162 Gillett Road, Thornton Heath, CR7 8SN

Design and Access Statement

Planning application – For proposed internal reconfiguration and refurbishment to increase the number of units with a change of use from 18 bedsits (previously) to a total of 23 HMO units.

Revision: A

DRAWING TITLE
Site Plan

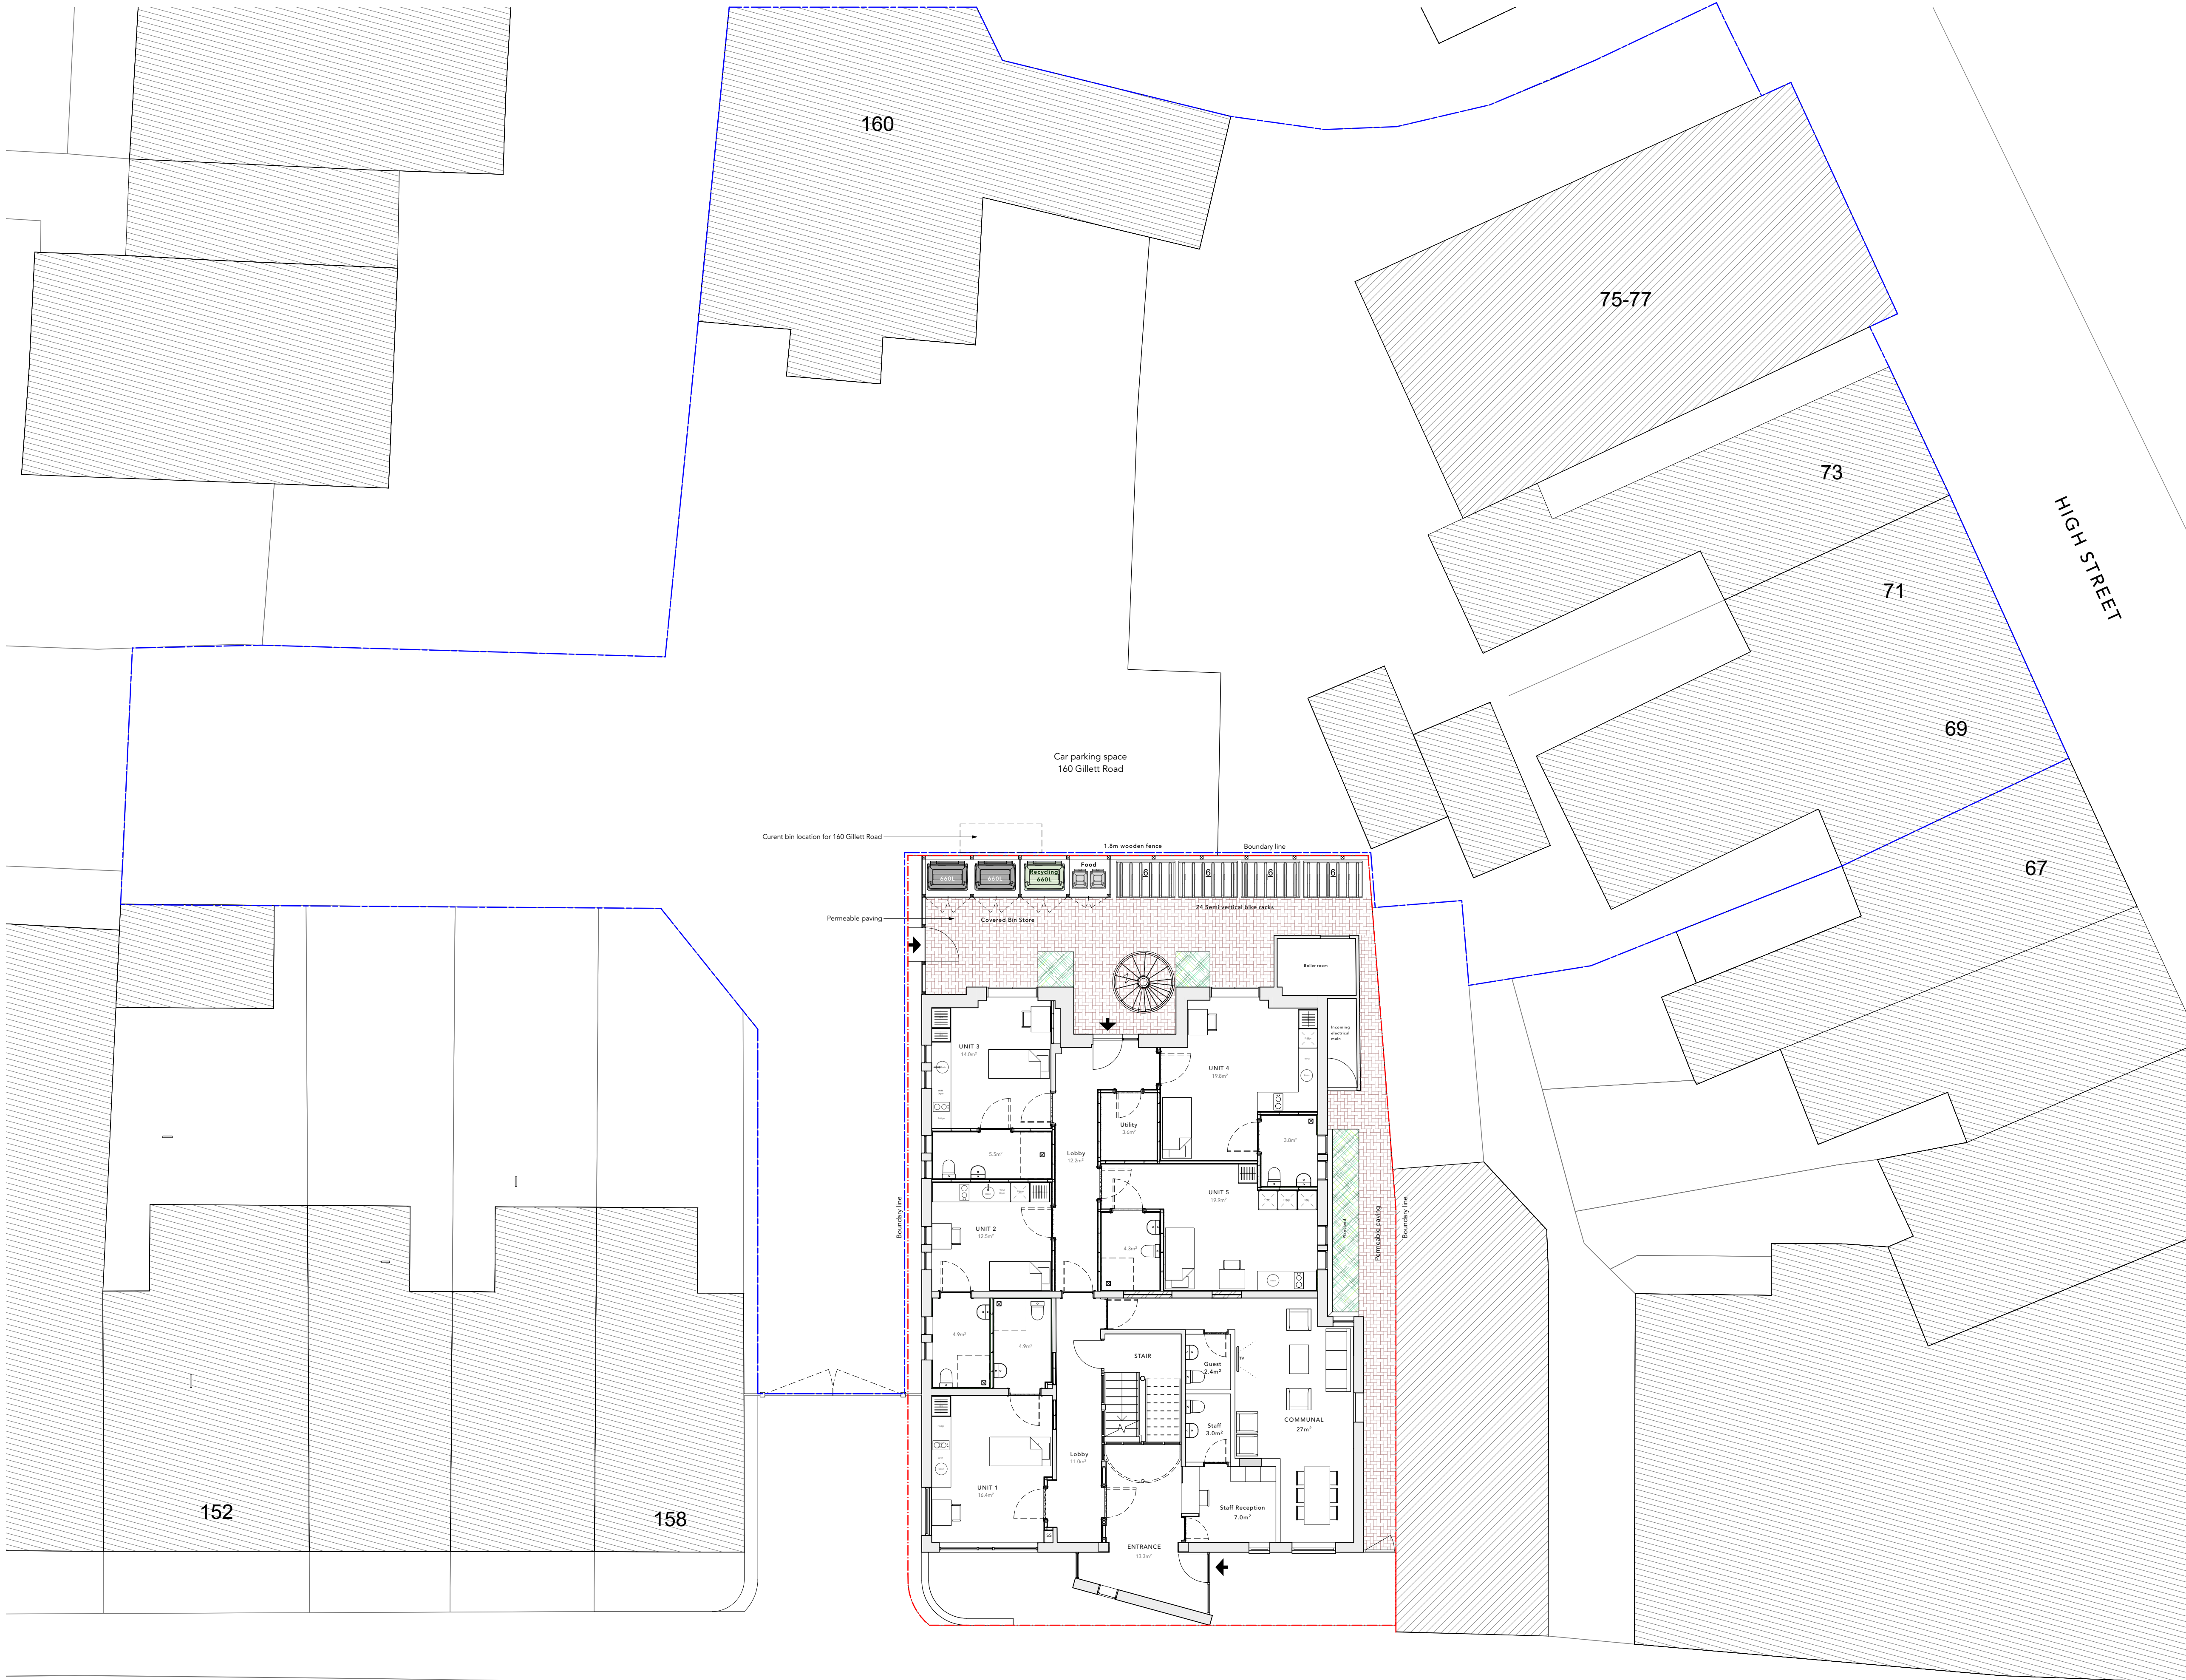
Officers comment: The proposal appears to provide 6 x Sheffield stands at the rear which would provide space for parking 12 bikes. This would be an under-provision for 27 units and would need to be amended. Cycle storage should be secure and should comply with the standards set out within the London Cycle Design Standards.

Officers comment (1): *“Refuse storage should be designed in from the outset in accordance with Local Plan policy DM13. Refuse storage is shown at the rear comprising 12 individual wheelie bins. It would be more sensible to provide communal bins.”*

Officers comment (2): *“Bin storage must be provided in accordance with guidance set out in the Council’s ‘Waste and Recycling in Planning Policy Document’ (2015). This outlines, amongst other things, that a bin collection point should be no more than 20m from the collection vehicle to enable operatives to collect, and that residents should not be required to walk more than 30m to deposit their waste.”*

Response: 24 semi vertical bike racks are being proposed in the revised scheme located at the back of the property with main access at the left-hand side through a secured gate.

Response: Bin storage area has been redesigned in the amended scheme to provide a larger communal bins and have been split into general waste, recycling bins (comingled recycling, paper/card recycling) and a food recycling bin. Access for operatives is within 20 meters and located in the same area as refuse bins for 160 Gillett Road.

DRAWING TITLE
**Floor Floor
Existing & Proposed**

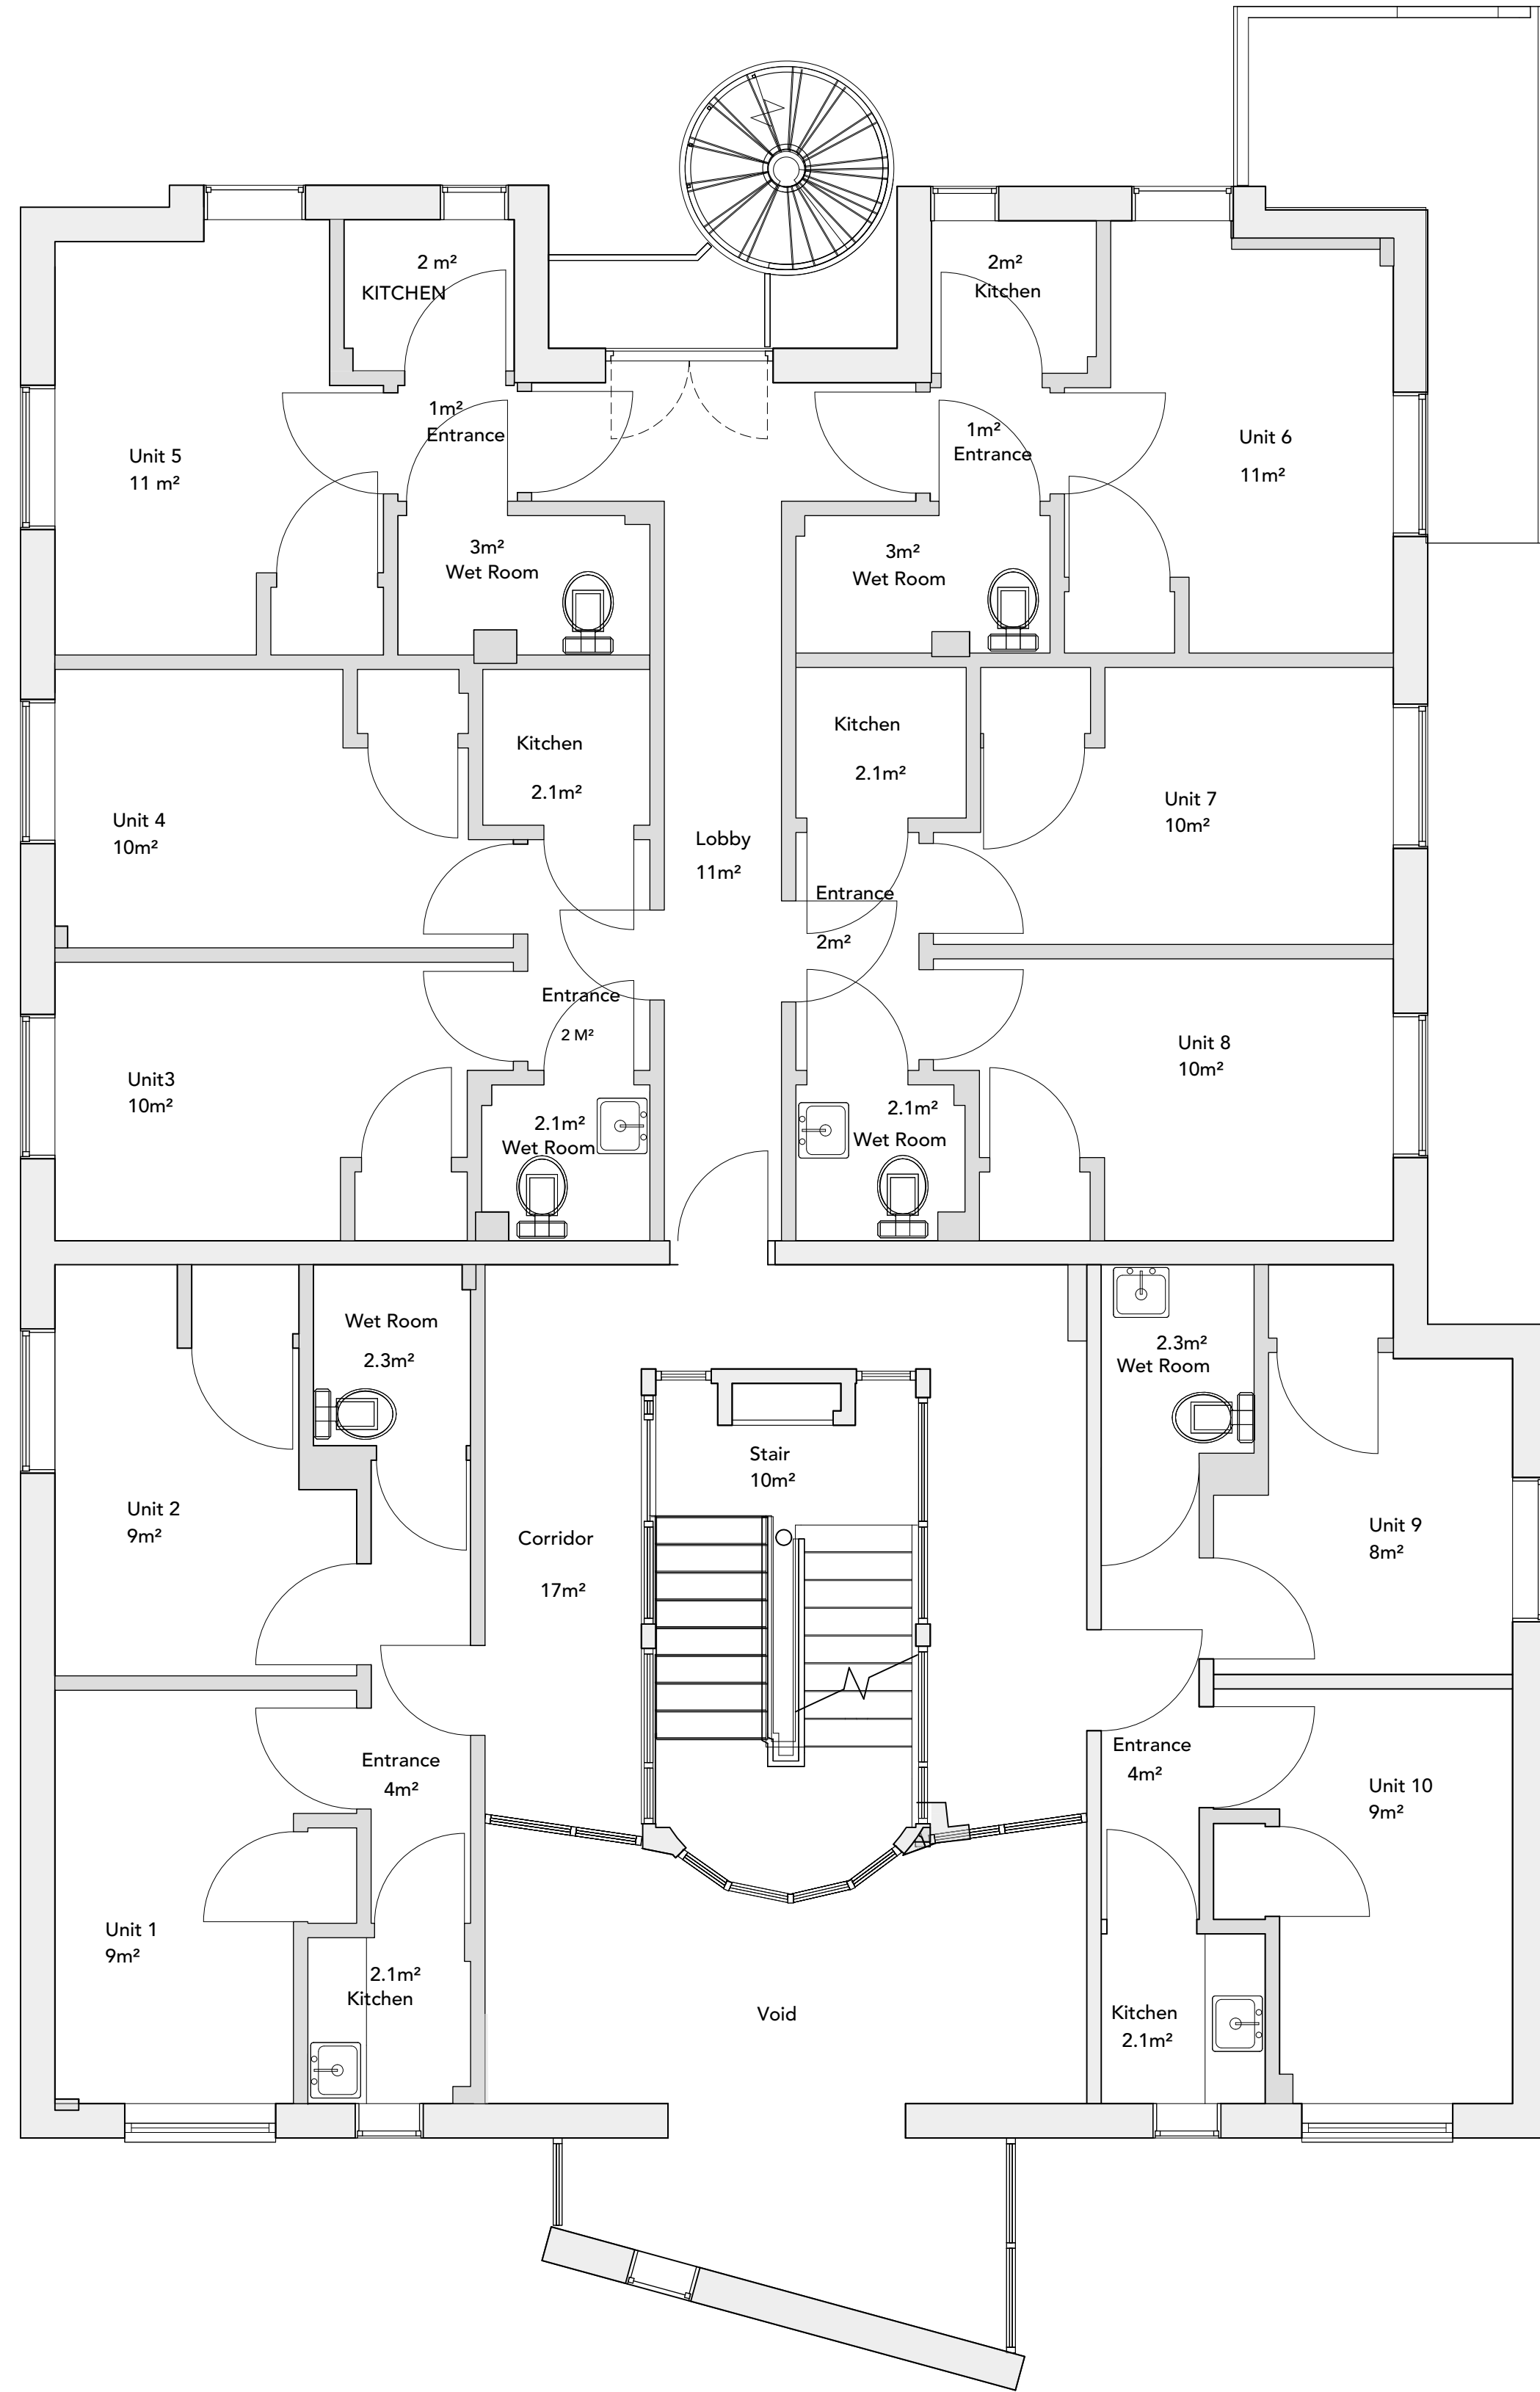
Officers comment (1): As proposed, each unit has a private kitchenette and space for a double bed and a small table. Each unit has a window for outlook and ventilation. The Council's HMO standards document outlines that a single room with a kitchen for 1 person should be 13.5sqm in area, or 18.5sqm for 2 people, whereas the proposed rooms are generally smaller than this. Wet rooms are proposed on a 1:1 basis but these are accessed from the communal corridors. The Council does not have any guidance on whether wet rooms should be accessed from private or communal spaces; this can be guided by the proposed use.

Response: All units are currently single occupancy, cooking facilities have been removed from the units on first and second floor, ensuite shower room now provided. Minimum space requirements for single rooms with ensuite shower room according to Croydon HMO standards is 12.5m² – all the rooms on the first and second floor meet those requirements.
